10 April 2012

SYDNEY OLYMPIC PARK SITE 43/44 PROJECT REVIEW MEETING – 29 MARCH 2012

drawing
MASTERPLAN - TYPICAL
BASEMENT

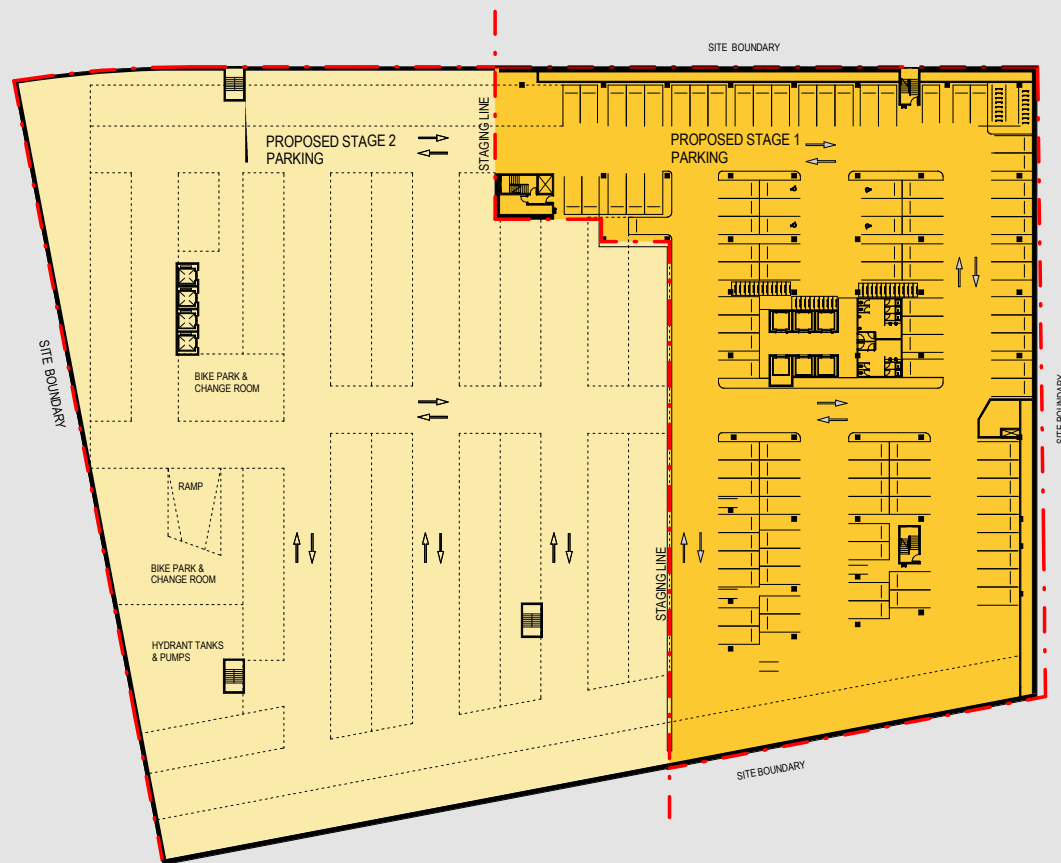
In addition to the above, SOPA remains concerned about the location of the basement ramp within the future public road. Discussion during the meeting as to why the ramp can not be relocated as suggested by SOPA, or to other alternative locations was not clear. The discussion has not resolved the matter to SOPA's satisfaction and the reasoning remains unclear. You stated that the existing tenant has a ground lease over the area SOPA identified as an alternative location for the ramp and therefore it could not be constructed at this location. The area SOPA

identified has basement carparking below and will be part of the construction area, if the building is constructed, therefore surface carparking could not be provided in this location for the existing tenant while the building is under construction. It is unclear how the building could be constructed according to the Development Applications plans if Capital Corporation is unable to construct the basement within the existing tenants ground lease area.

Capital Corporation therefore needs to provide, as part of your presentation to the April 2012 SOPA DRP, clear explanation as to why the ramp can not be relocated; how, if approved, basement construction will or will not occur in the area of the existing lease; and what other impacts the existing lease area impediment will have on the overall design and development execution.

drawing SOUTH WEST ELEVATION

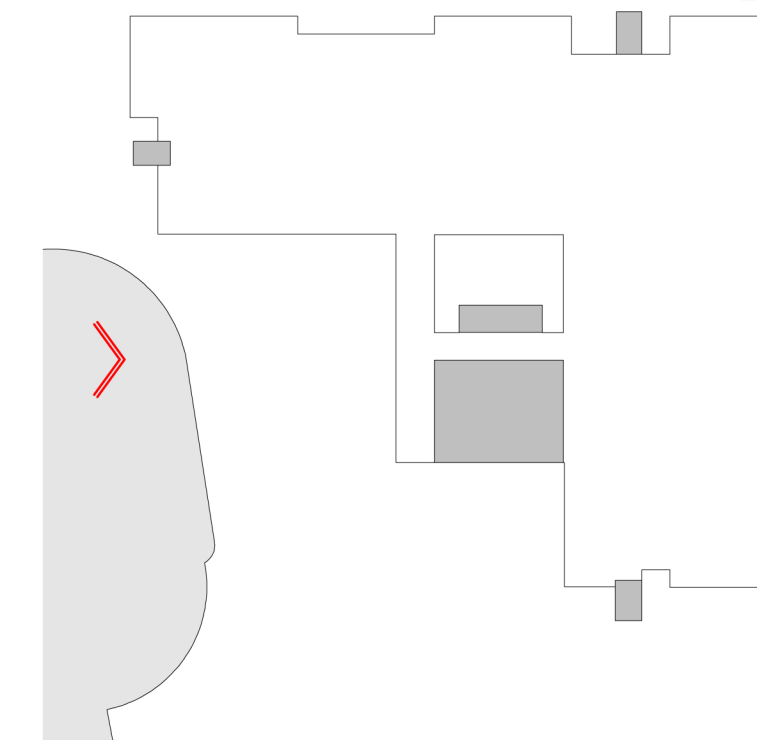
- Item 1.3.1 – Proposed facade changes (including replacement of the staggered vertical blades with simplified vertical blades, and the introduction of screening devices such as vertical sunshading blades and horizontal tubing) were supported in principle, but are subject to review by the Design Review Panel (DRP) on 19 April 2012.
